Rezoning Transportation Analysis
Petition Number: Insert Zoning Petition #2020-191
General Location Identifier: Tax ID 08117646

Revision Log:	Date	Description
	01-21-21	First Review (WB)

**RZ.01**

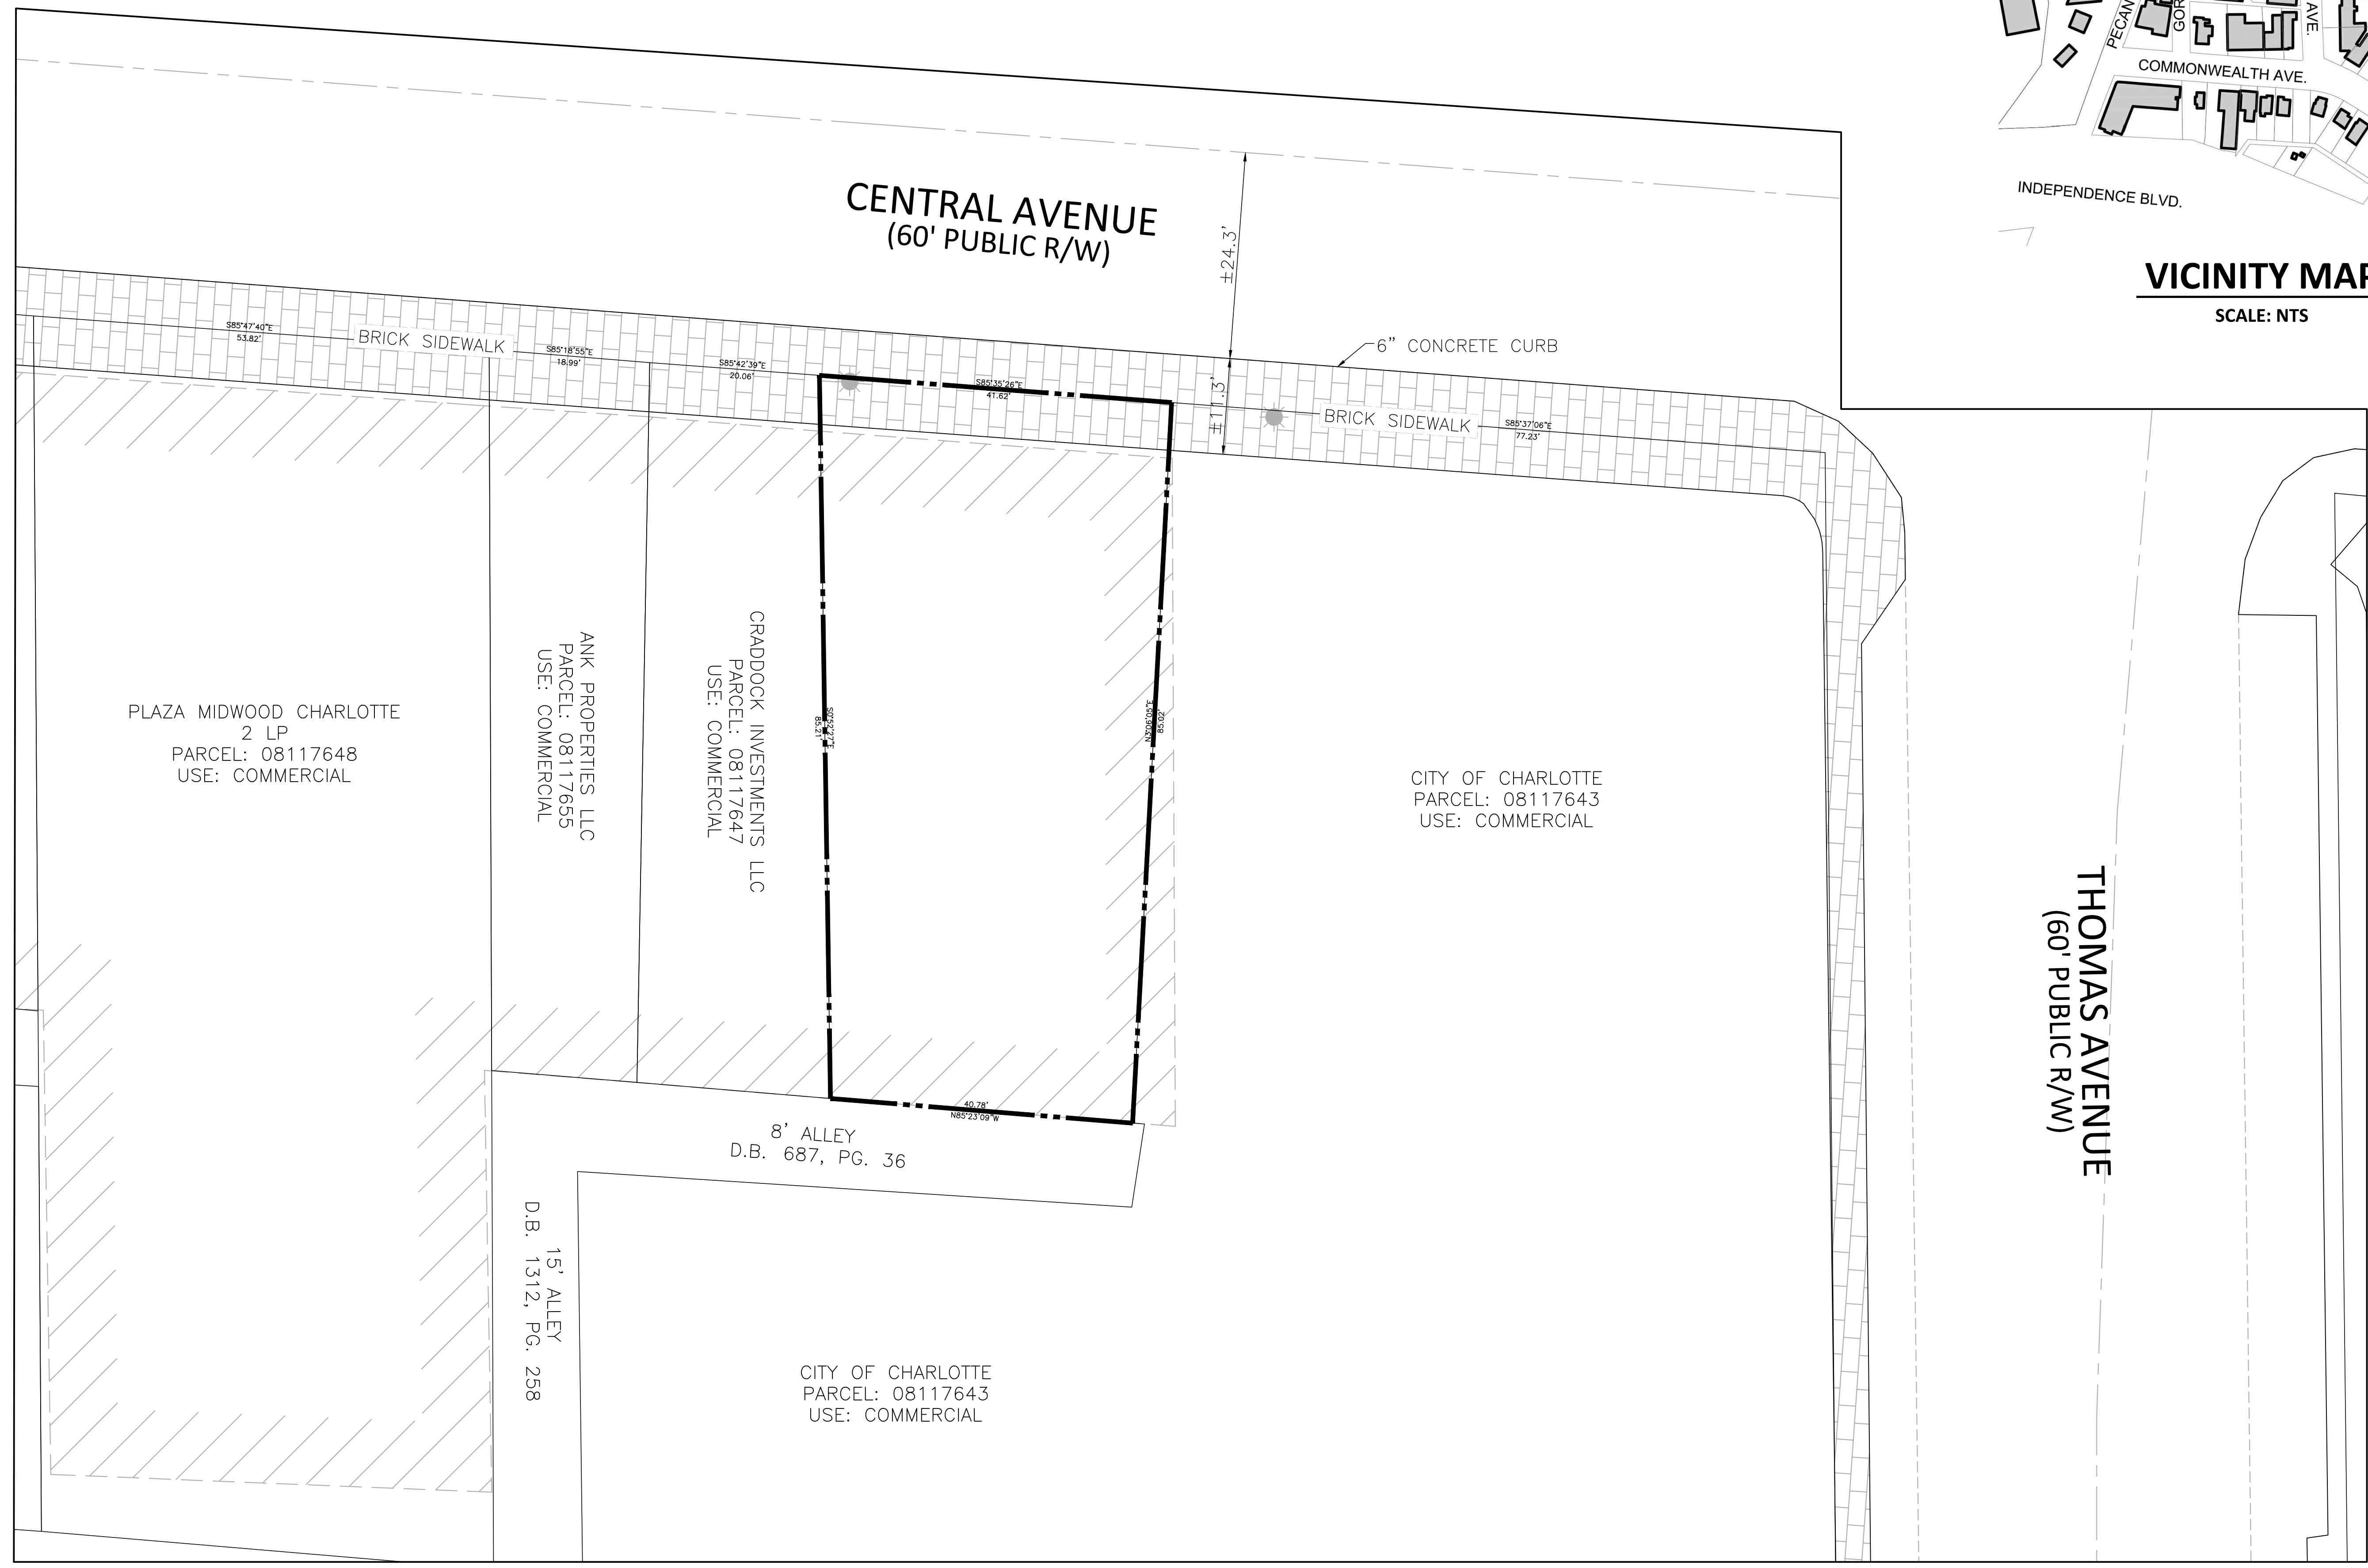
1. **Curbline:** The proposed zoning district has a setback measured from back of the existing or proposed future curbline.
 - a. **Central Avenue:** The future location of curb and gutter is in its existing location.

Label and dimension the curb and gutter from the centerline for each road on the site plan.

3. Revise site plan and conditional note(s) to commit to dedicate 40' right-of-way from the road centerline. The site plan shall label and dimension the right-of-way from the road centerline.
